Please could you also upload the email below and the attached revised drawings and documents onto Ocella for **BN/28/20/DOC** regarding Angels Nursery, Yapton Road, Barnham.

Please see our further comments regarding surface water drainage relating to BN/28/20/DOC. 16/06/20 review comments are shown in *red italics*, items that are now closed are struck through.

Comments on surface water drainage (these comments also relate to BN/28/20/DOC);

PRECAST CONCRETE CONTROL CHAMBER

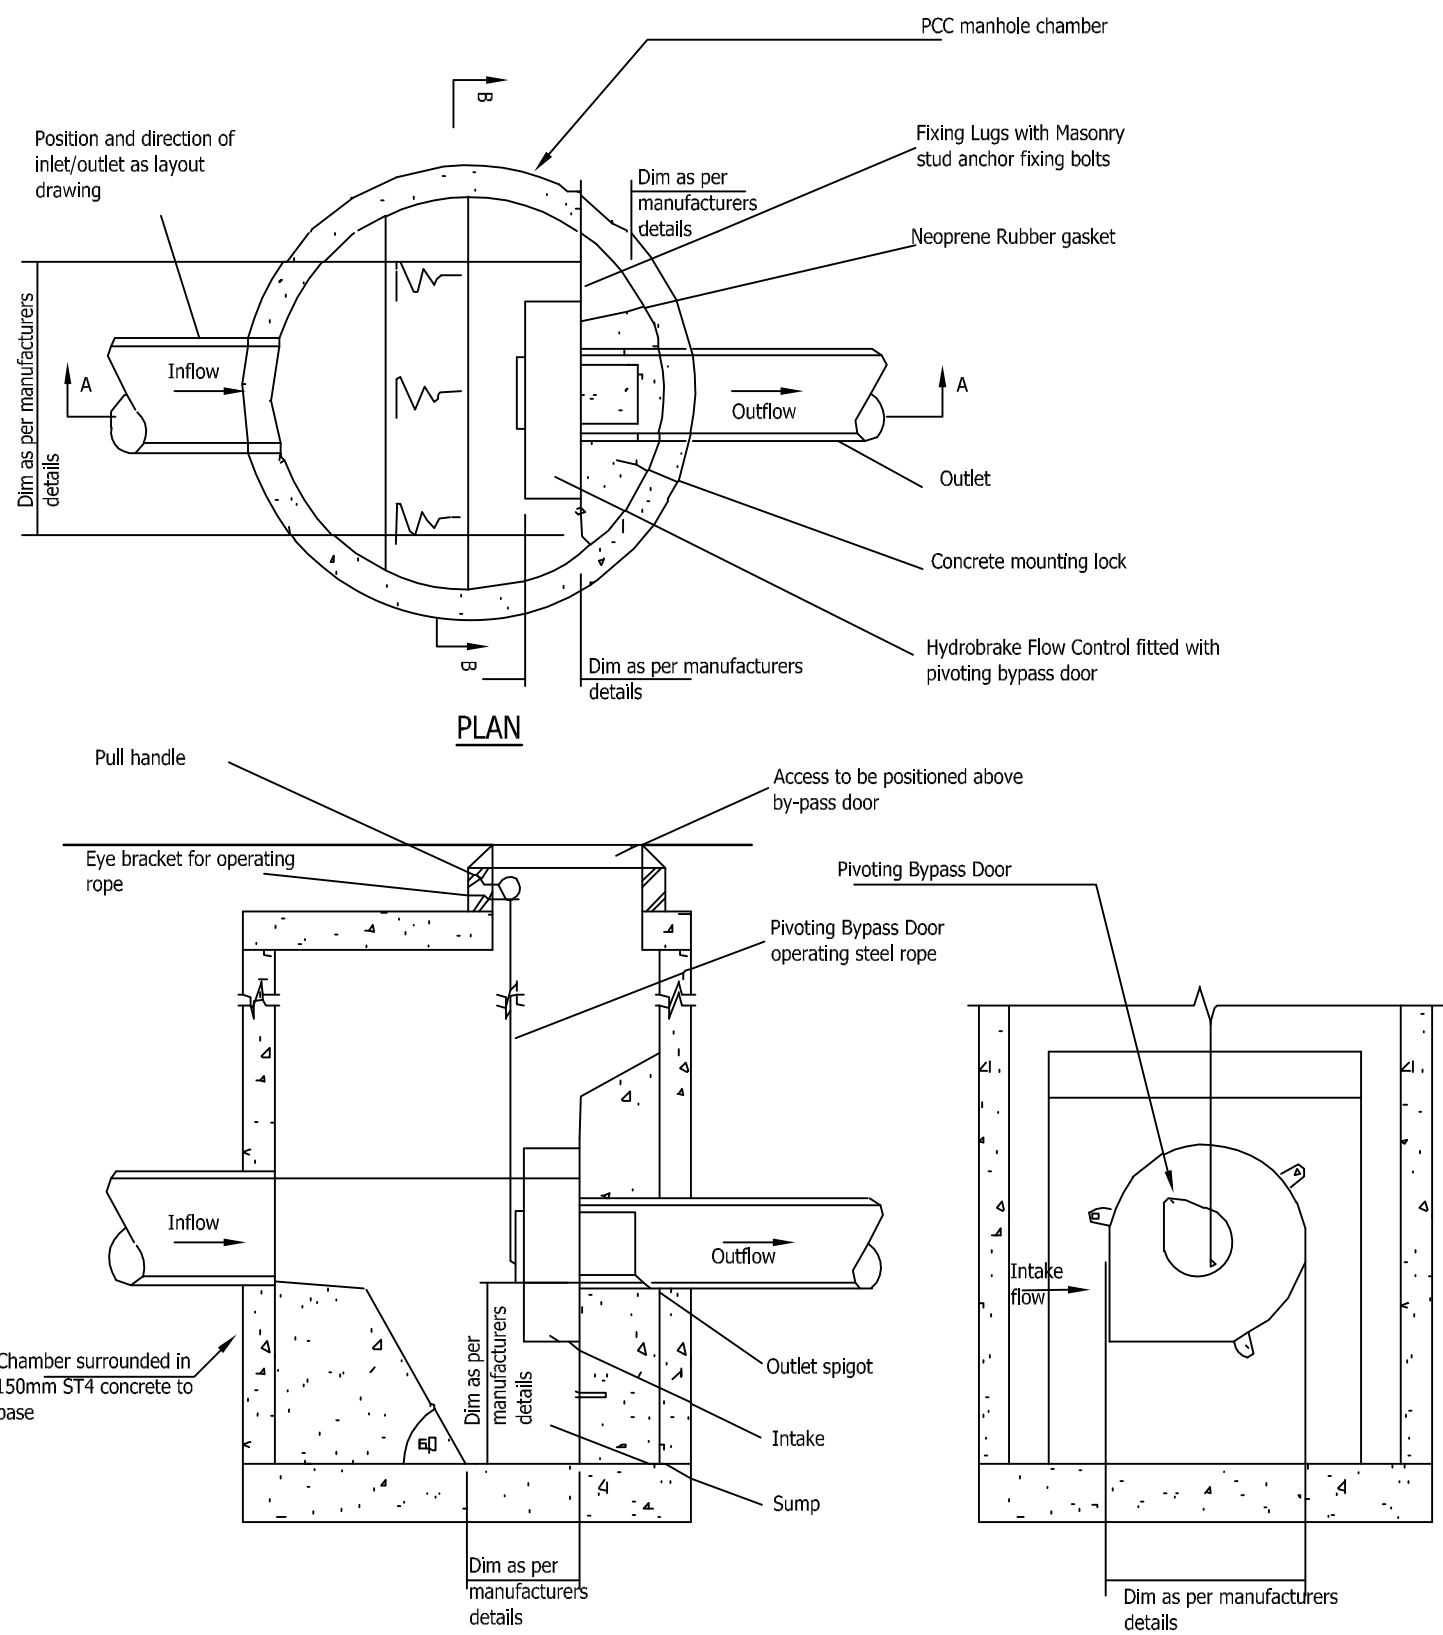
64. Hydrobrake chamber detail – rings to be surrounded in 150mm thick concrete and to be extended down to the bottom of its base. All to be ST4 concrete. Add benching construction notes and include hydro international details referred to. *Note is not clear that surround extends to bottom of base, benching note missing, hydro international details not included.*

64. Hydrobrake chamber detail – rings to be surrounded in 150mm thick concrete and to be extended down to the bottom of its base. All to be ST4 concrete. Add benching construction notes and include hydro international details referred to.

CONCRETE BAFFLE DETAIL

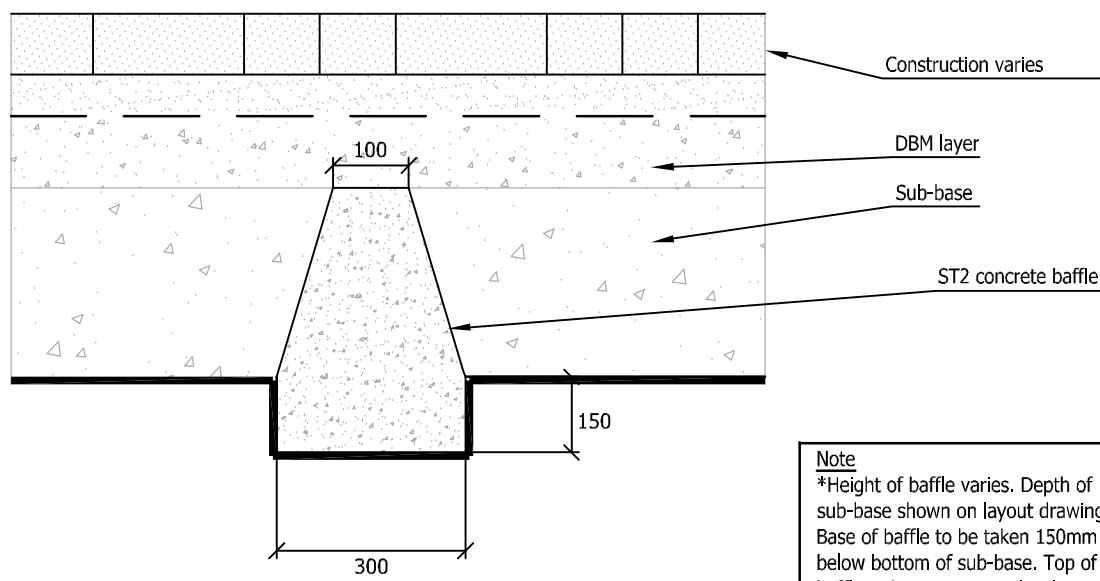
70. Provide sloping formation permeable paving detail. *Please provide.*
71. ~~Baffle detail—Make it clear that the top of the concrete is level with the top of the sub base.~~ *Okay.*

70. Provide sloping formation permeable paving detail.
71. Baffle detail – Make it clear that the top of the concrete is level with the top of the sub base.

DISTRIBUTION/COLLECTOR TANK DETAIL WITHIN
TANKED PERMEABLE PAVING (MARKED DT ON LAYOUT)

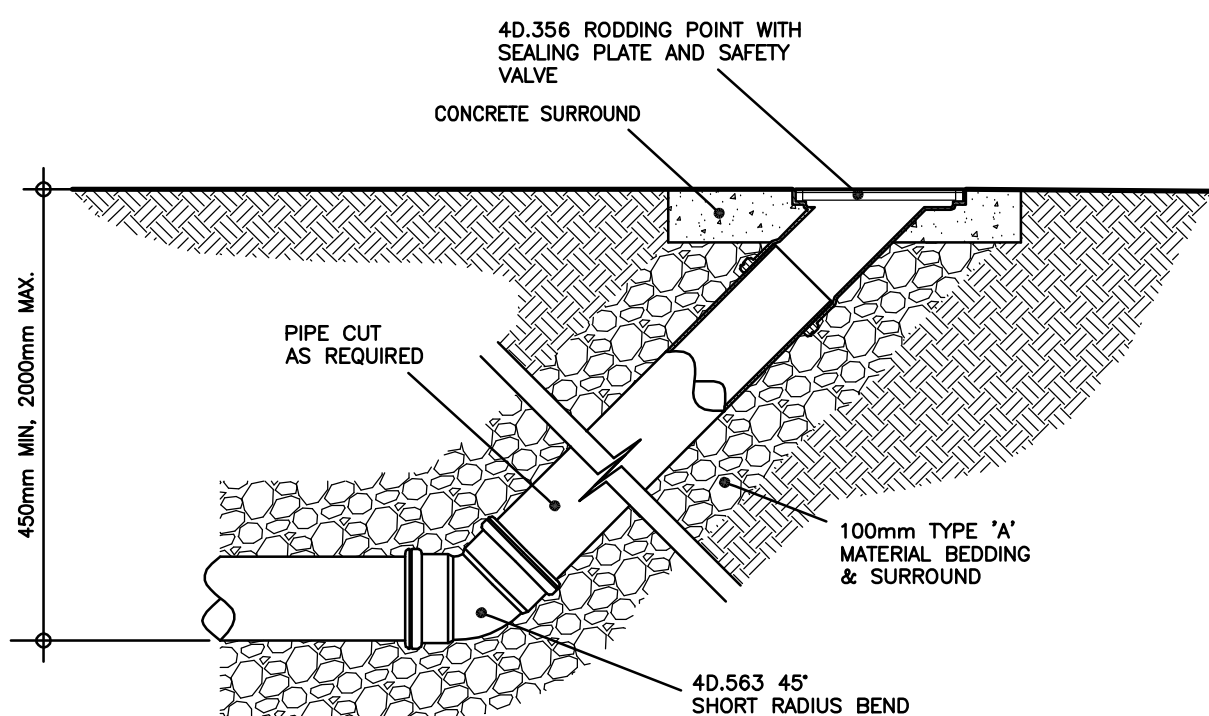
73. Provide construction detail distribution tanks on permeable paving outlets. *Please make it clear that invert level of outlet tanks is at formation level.*

72. Provide pond construction detail including impermeable liner and any necessary anti-buoyancy measures. Floation calcs to be provided.
73. Provide construction detail distribution tanks on permeable paving outlets.

TYPICAL PRECAST CONCRETE
CATCHPIT-D210.2

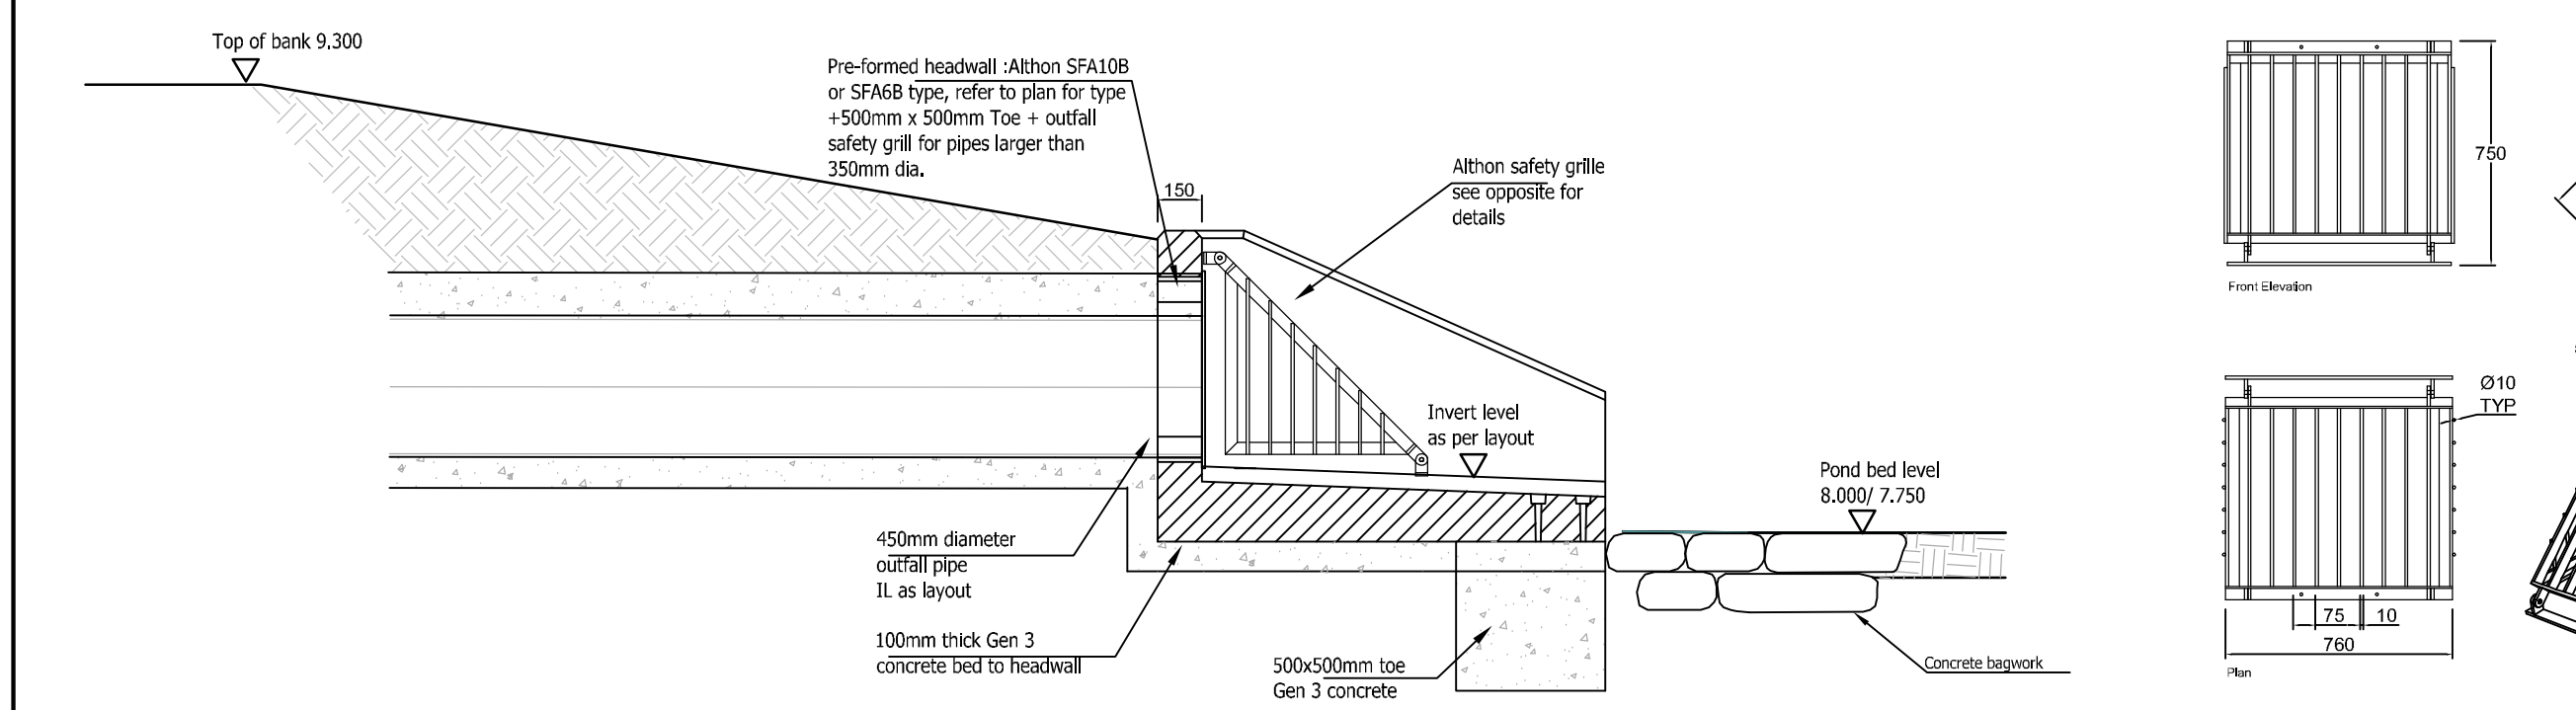
65. PCC ring catchpit detail – unsure if this type is being specified anywhere? If, so detail where and include brickwork under manhole cover/frame and extend concrete surround up to top of cover slab. Specify ring diameter. *Unclear as to where specified, include MH schedule.*

65. PCC ring catchpit detail – unsure if this type is being specified anywhere? If, so detail where and include brickwork under manhole cover/frame and extend concrete surround up to top of cover slab. Specify ring diameter.

SHE-0123-7300-1200-7300
Hydro-Brake Optimum®

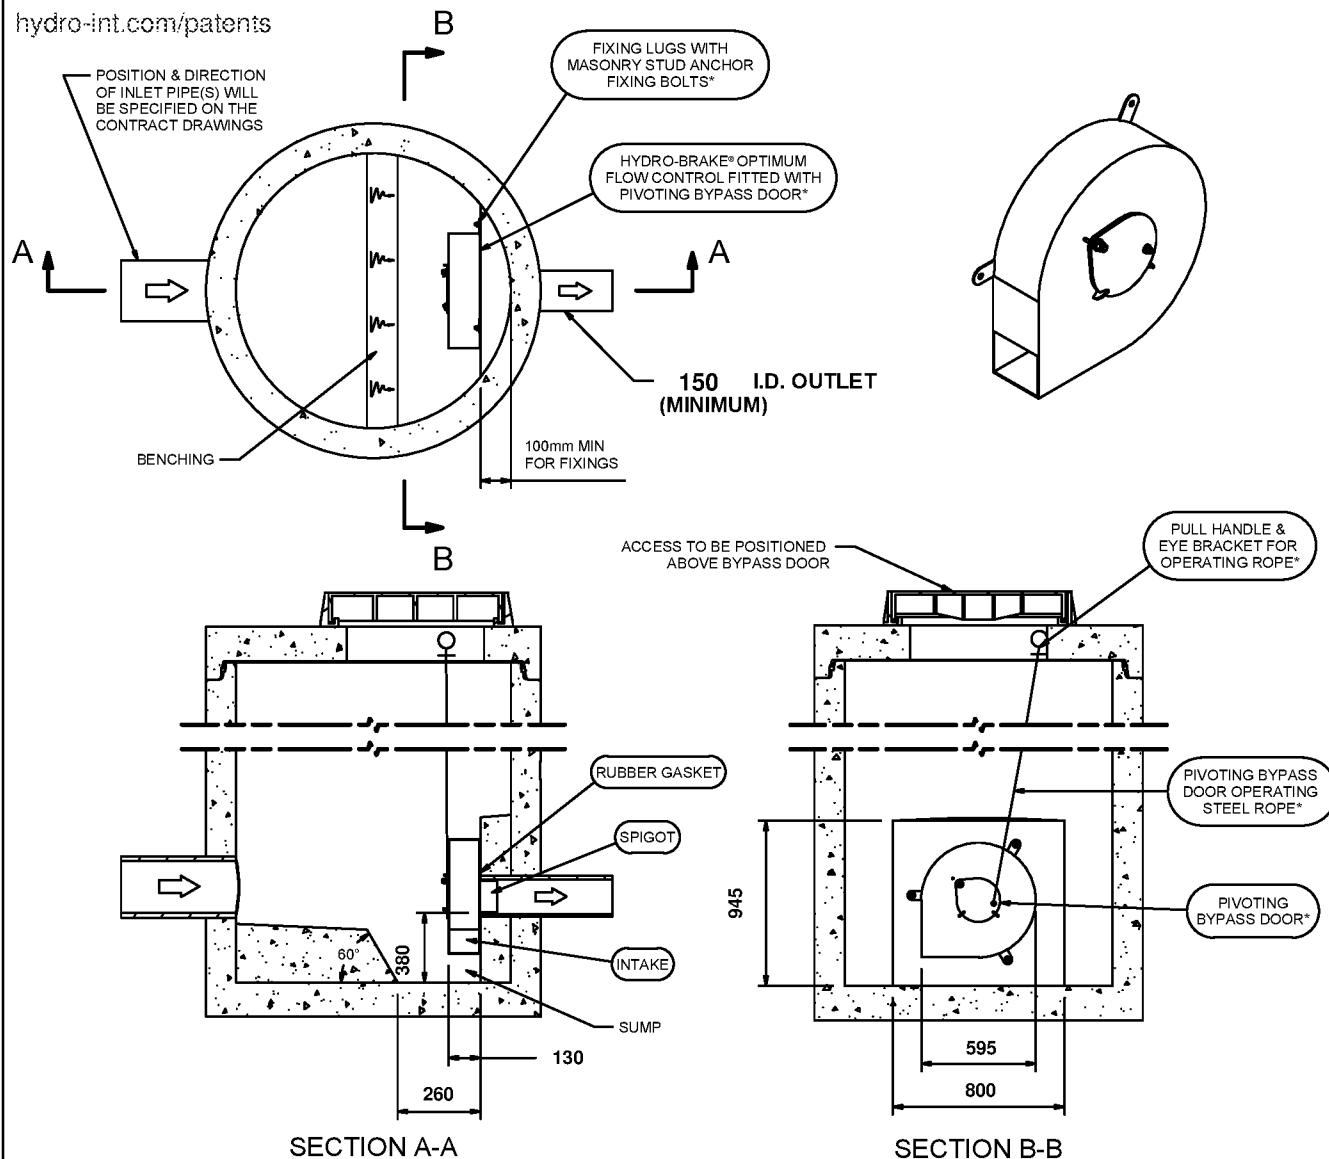
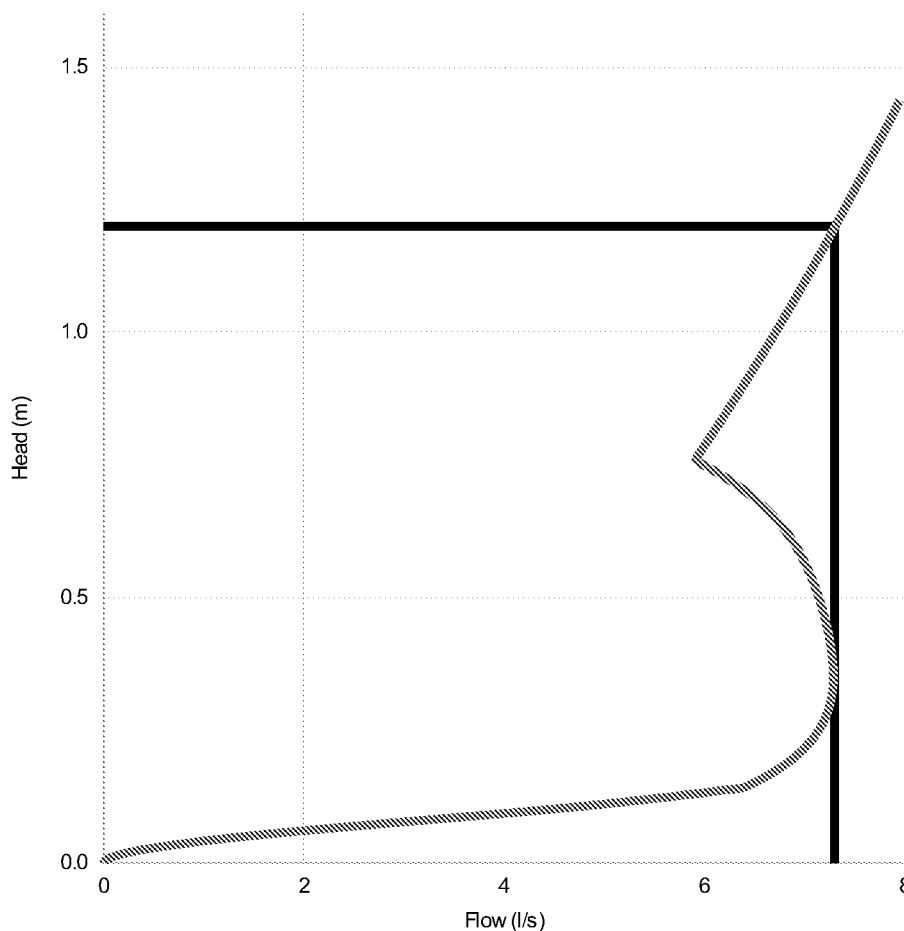
48. Hydrobrakes – provide manufacturers technical data sheets. *Please provide.*
49. Where pipes cross the diverted foul rising main – has this been checked for clashes? *Please confirm.*

48. Hydrobrakes – provide manufacturers technical data sheets.
49. Where pipes cross the diverted foul rising main – has this been checked for clashes?
50. 450mm inlet pipes to pond to have 'cranked' grilles.
